28 April 2020

TfNSW Reference: SYD18/01120/04

DPIE Reference: SSD 9483

CONSTRUCTION OF NEW EDUCATION BUILDINGS AT THE CHATSWOOD PRIMARY SCHOOL AND CHATSWOOD HIGH SCHOOL – 5-24 CENTENNIAL AVENUE

UPGRADES TO CHATSWOOD PUBLIC SCHOOL AND CHATSWOOD HIGH SCHOOL
 GENERAL ARRANGEMENT PLAN - PACIFIC HIGHWAY

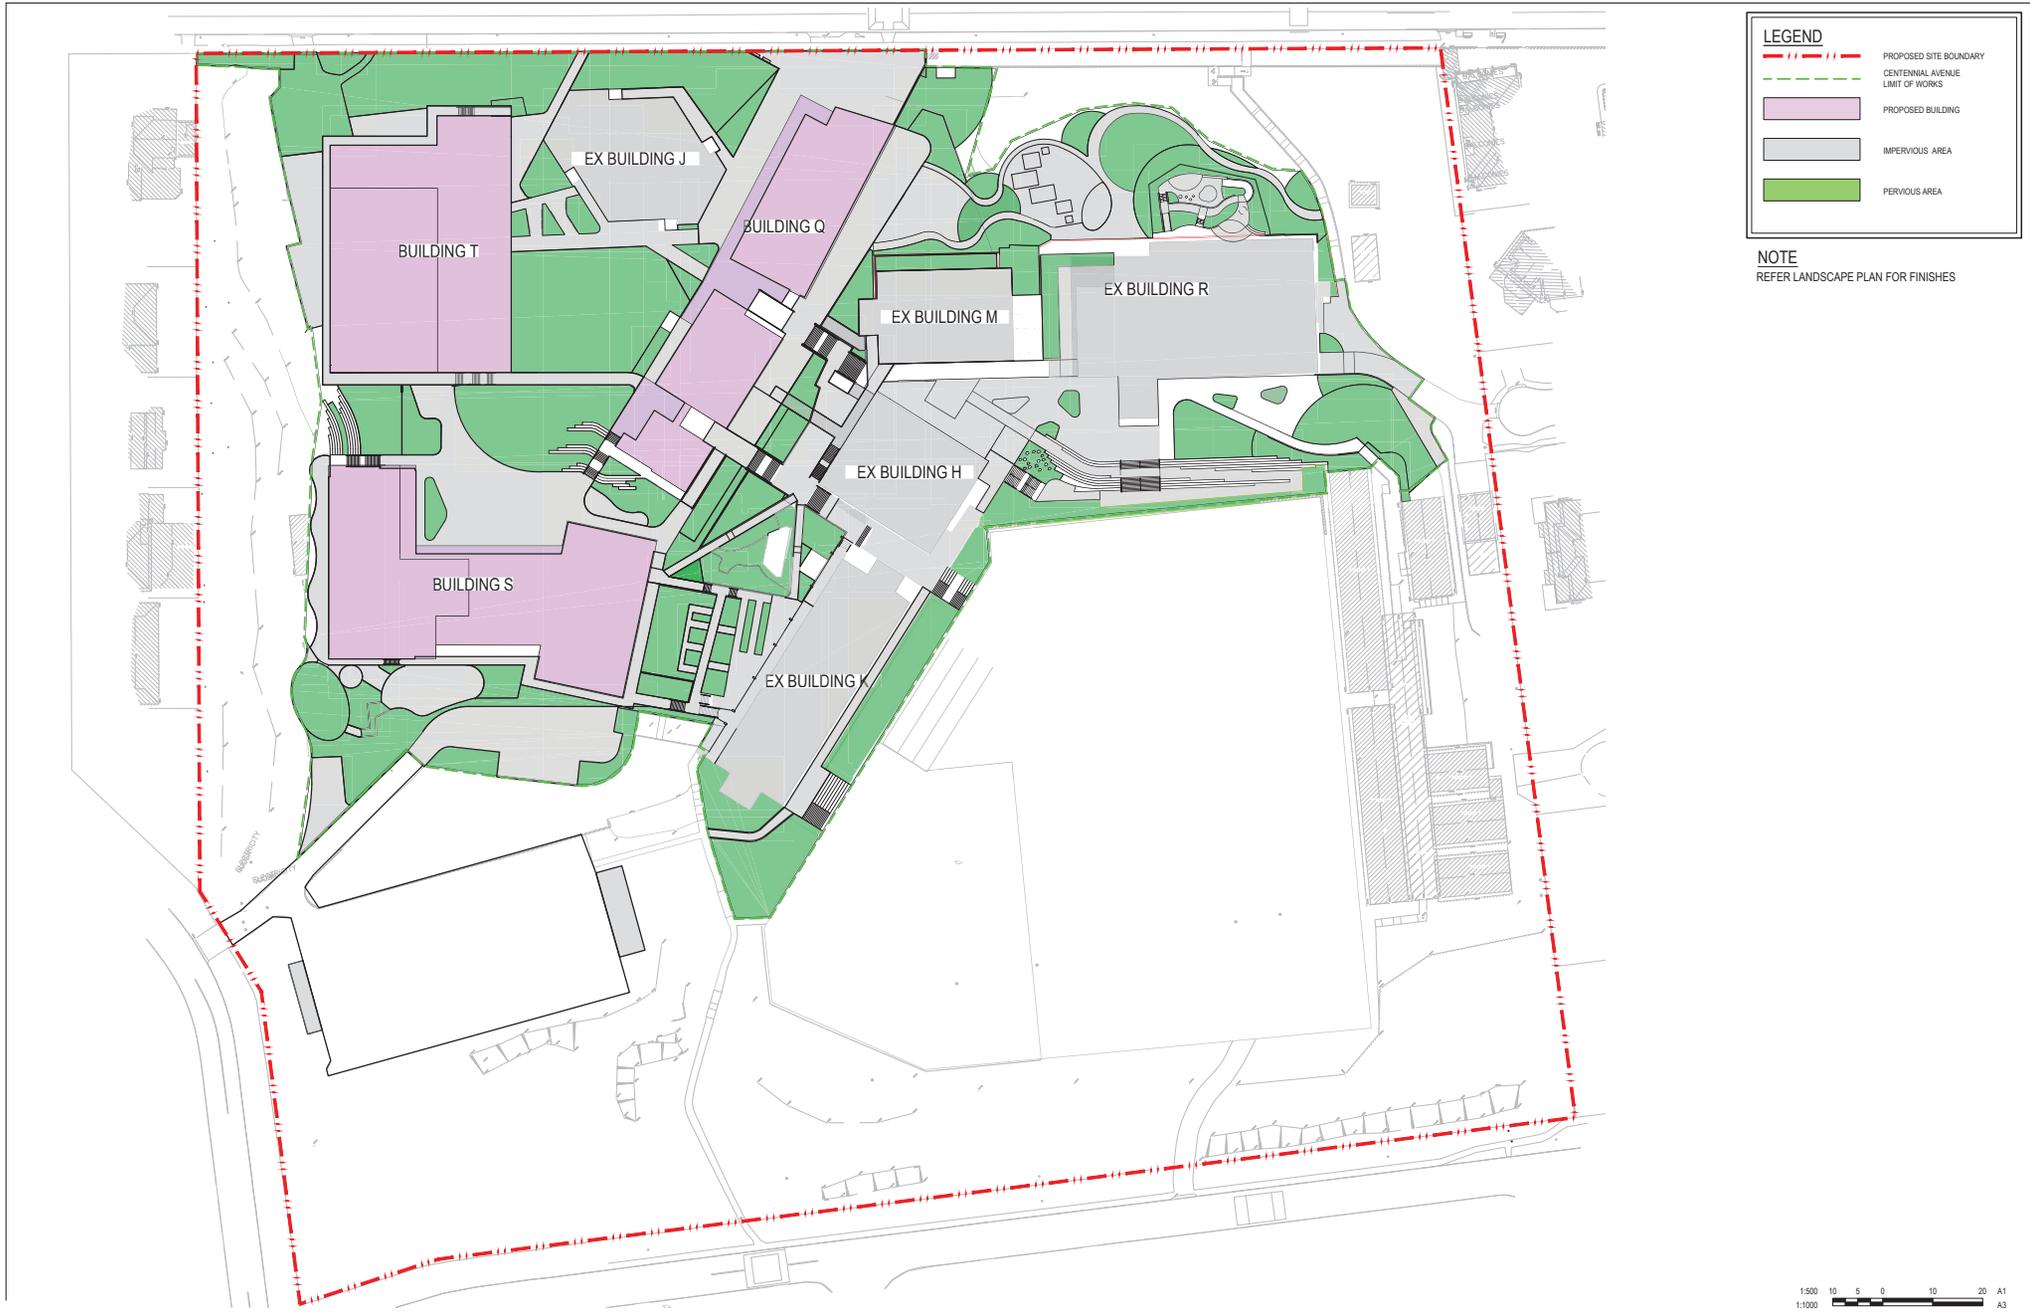
1. TfNSW has previously resumed and dedicated a strip of land as road along the Pacific Highway frontage of the subject property, as shown by grey colour on the attached Aerial – "X". All buildings and structures, together with any improvements integral to the future use of the site are to be wholly within the freehold property (unlimited in height or depth), along the Pacific Highway boundary.

2. The Chatswood Public School has alternative vehicular access via the local road network, and as such the proposed construction vehicular access and proposed emergency and service vehicular access on the Pacific Highway is not supported on road safety and efficiency grounds.
